**KIRKLEES METROPOLITAN COUNCIL  
INVESTMENT & REGENERATION SERVICE**

Reference No:	<b>2026/70/90266/E</b>
Site Address:	Albion Street, Dewsbury, WF13 2AJ
Description:	Variation of conditions 2 (plans) and 3 (materials) on previous permission 2024/91263 for erection of garage and MOT servicing centre with associated works
Recommending Officer:	Nicole Helliwell

**DECISION – REFUSED**

## **Officer Report**

Proposed Rear Elevation  
Scale 1:50

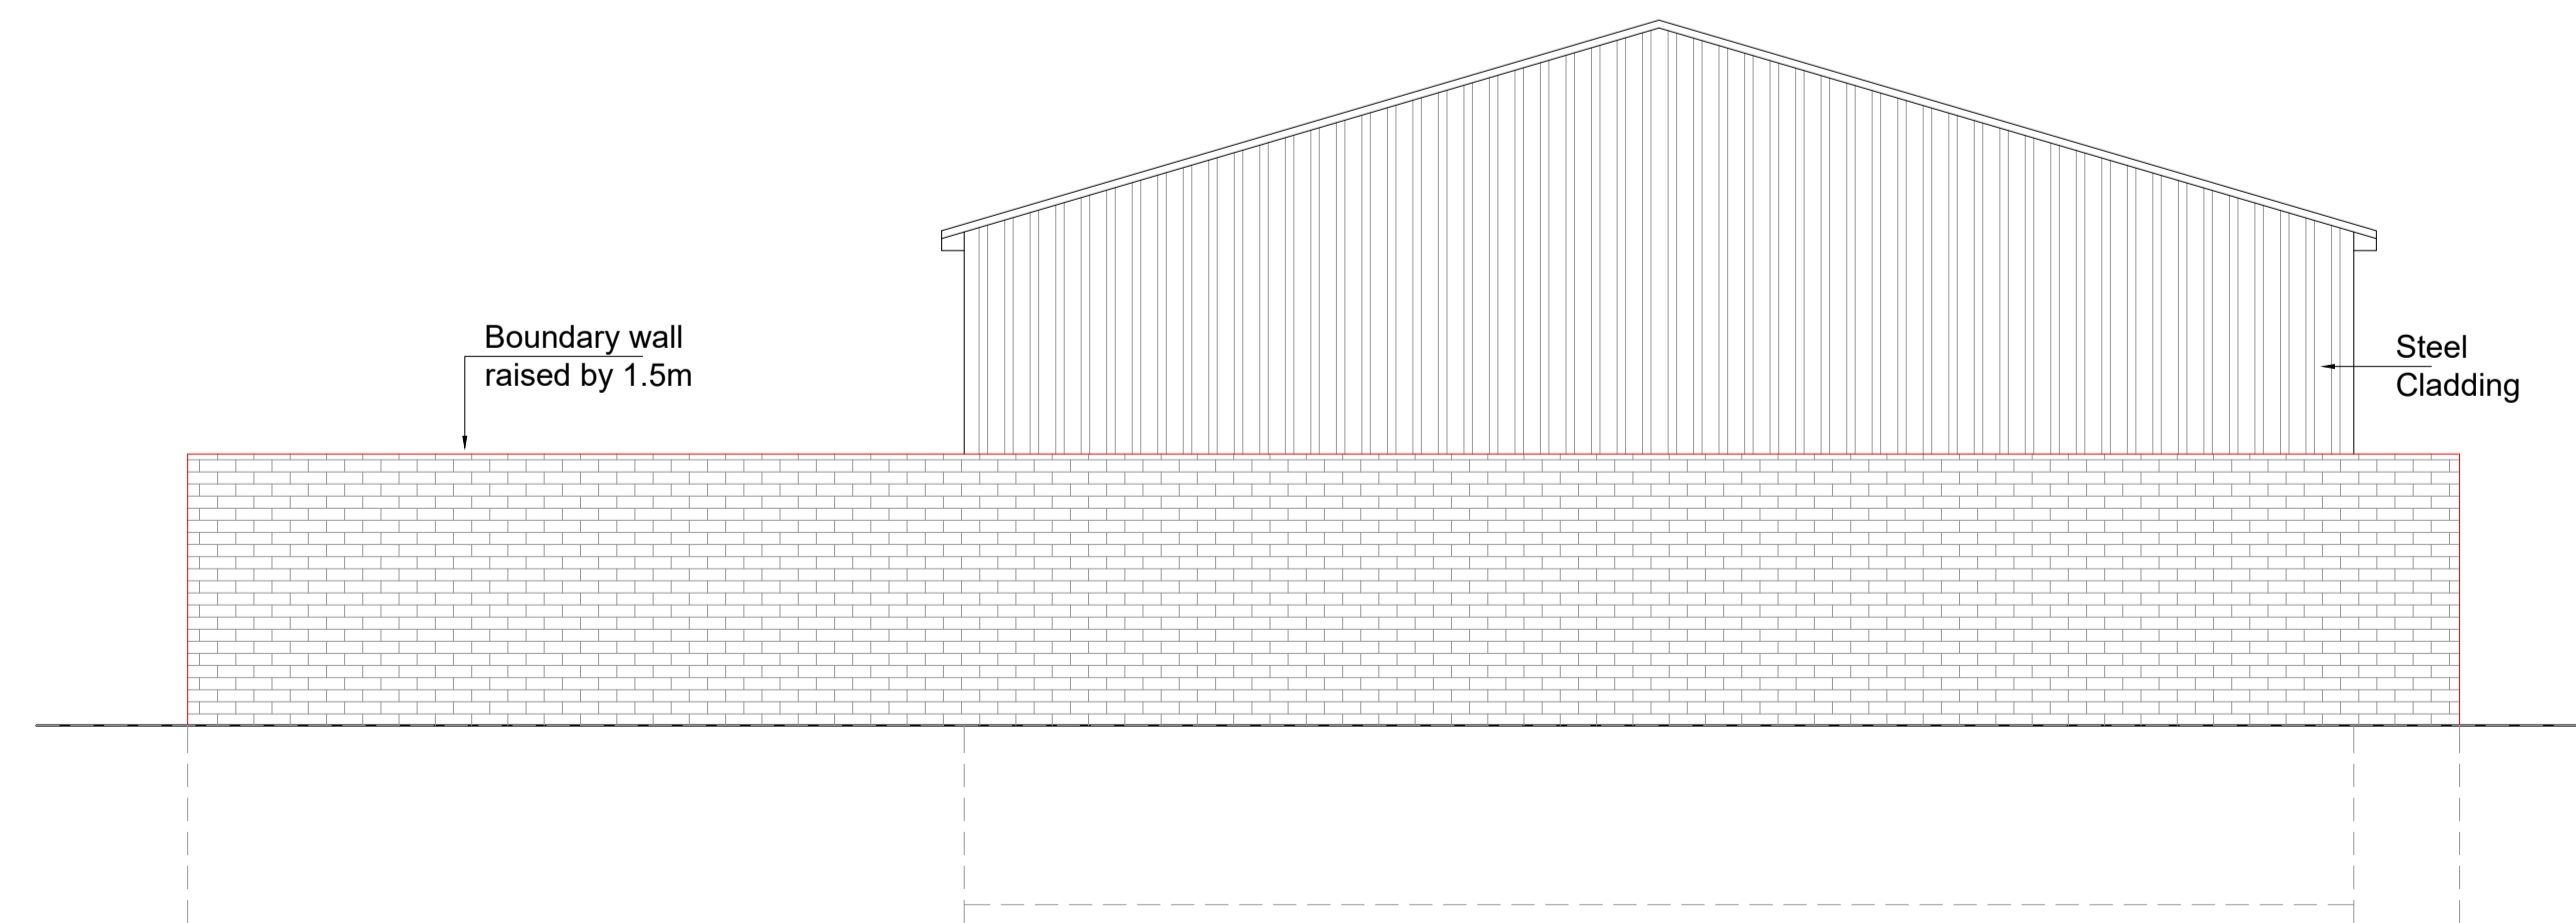
The submitted plans also confirm that the previously approved brickwork for the external walls and slate for the roof of the Garage and MOT servicing centre would be replaced with composite steel cladding. Whilst the increase to the boundary treatment would provide some form of screening, it is noted that the building would project well above the wall and due to the change in materials would appear unduly prominent and highly visible from public vantage points within the Northfields Conservation Area. Furthermore, it is considered that the material palette proposed would be out of keeping with the immediate building group and would fail to preserve or enhance the character of the Northfields Conservation Area.

The proposed variation of condition 3 would detrimentally harm the historic character of the Northfields Conservation Area. The alterations to the material palette would be out of keeping with the immediate building group and would increase the buildings prominence from public vantage points within the Conservation Area. There are no public benefits to outweigh the less than

substantial harm to the setting and character of the Conservation Area. Therefore, to permit the development would be contrary to Policies LP24 and LP35 of the Kirklees Local Plan, and Chapters 12 and 16 of the National Planning Policy Framework.

1. The material palette for the building proposed would be out of keeping with the immediate building group, detracting from public vantage points, detrimental to the historic character of the Northfields Conservation Area for which there is insufficient public benefit to outweigh the less than substantial harm to the setting and character of the Conservation Area contrary to Policies LP24 and LP35 of the Kirklees Local Plan, and Chapters 12 and 16 of the National Planning Policy Framework.
